Application: SSI 7485

I write regarding the proposed modification to M4-M5 Link, Mod 2 The Crescent overpass and changes to pedestrian infrastructure in North Annandale, Rozelle and Rozelle Bay Foreshore area.

**Figure 4 | Proposed modification** (Source: Design Amendment Report)

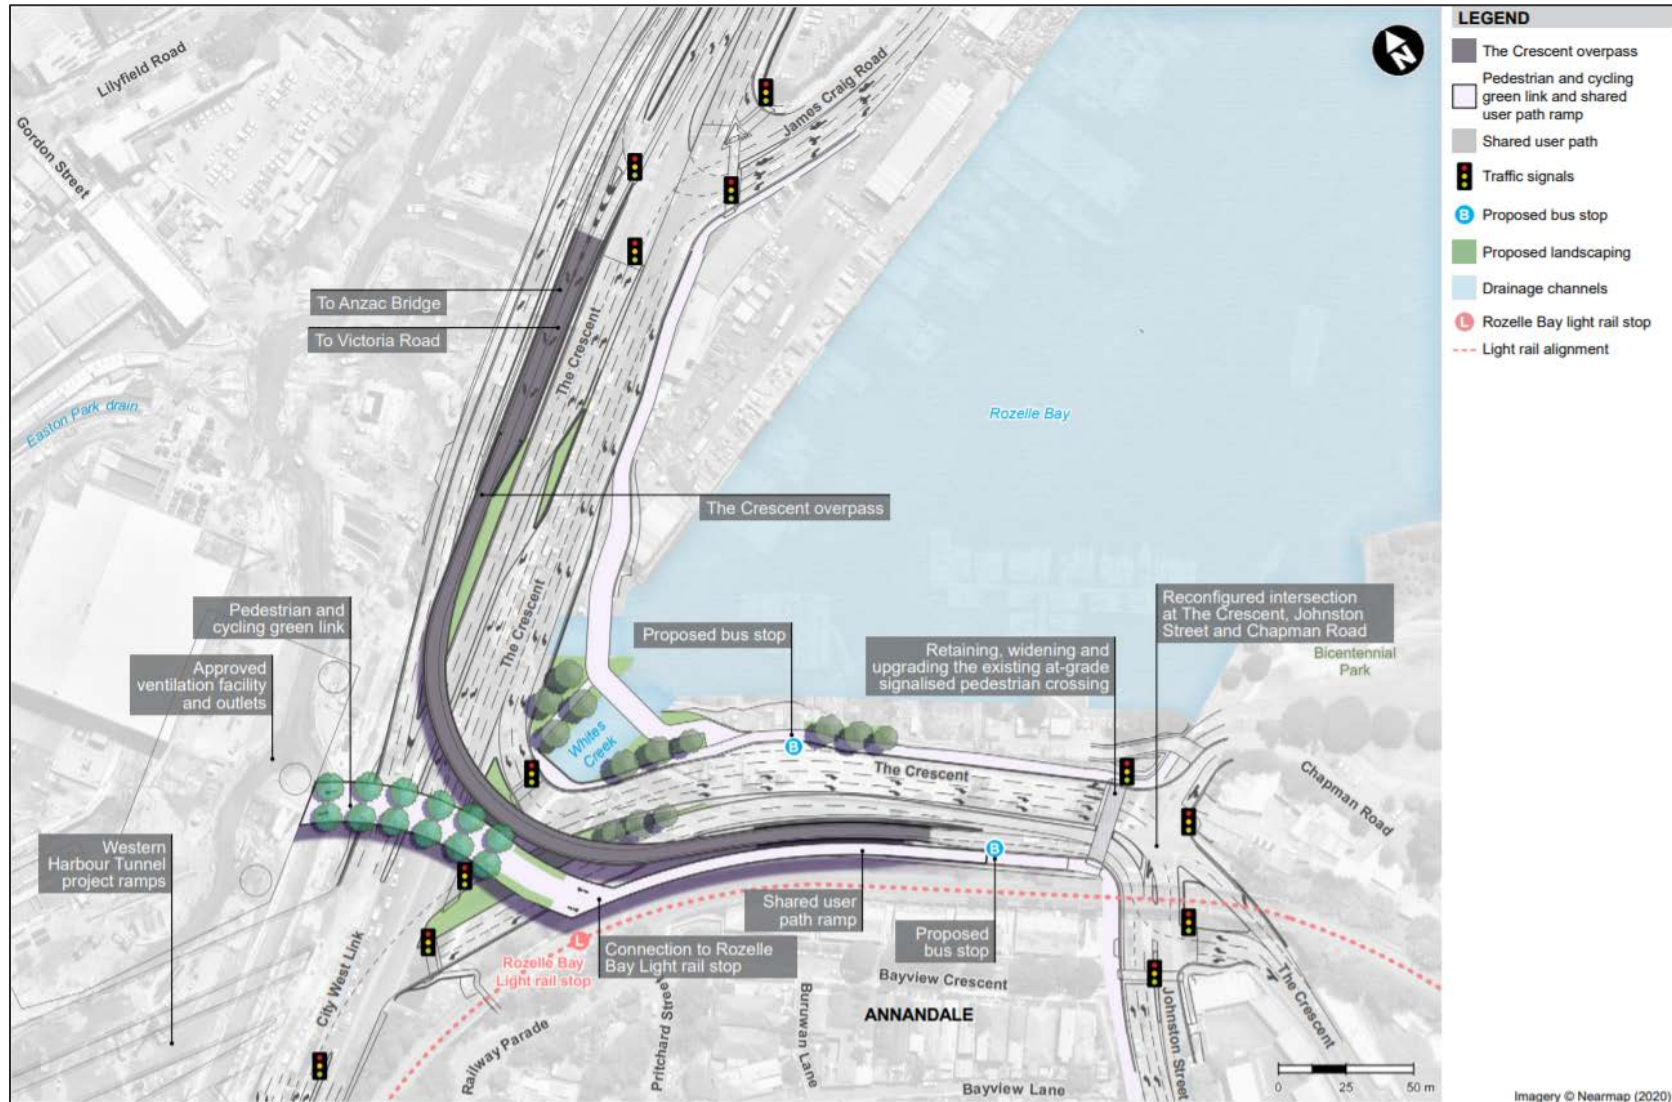
- The significantly reduced safety and increased risk for pedestrians and cyclists with removed access over The Crescent to Bicentennial Park and the increased traffic along Johnson Street.
- Being required to cross five sets of pedestrian lights at The Crescent as my option to reach the foreshore from Annandale or from Rozelle Bay light rail stop.
- Removal of direct active links to the foreshore, cutting the community off from the area and the proposed revitalisation of the entire Bays Precinct, including linking the Light Rail and Bus stops to a Ferry wharf and Metro station.
- Urban and landscape design that is being built before a finalised Masterplan for the area.
- Traffic changes that limit movements around the suburb and create further congestion in the local streets of Annandale, Forest Lodge, Glebe, Lilyfield and Rozelle with no planning to deal with these.

- Reinstate the GreenLink connecting communities and green open space from Rozelle to Bicentennial Park
- Relocate and design pedestrian and cyclist connections that are continuous, safe and direct.
- Design the modification infrastructure and active links in response to the character of the suburbs, the location of the foreshore and it's potential future development.
- Provide pedestrian and cyclist paths that maximise people safety and do not force them onto busier streets, unsafe concrete plazas and caged walkways.
- Integrate active and direct connections to all active transport – including the future Metro West and Foreshore Ferry Wharf
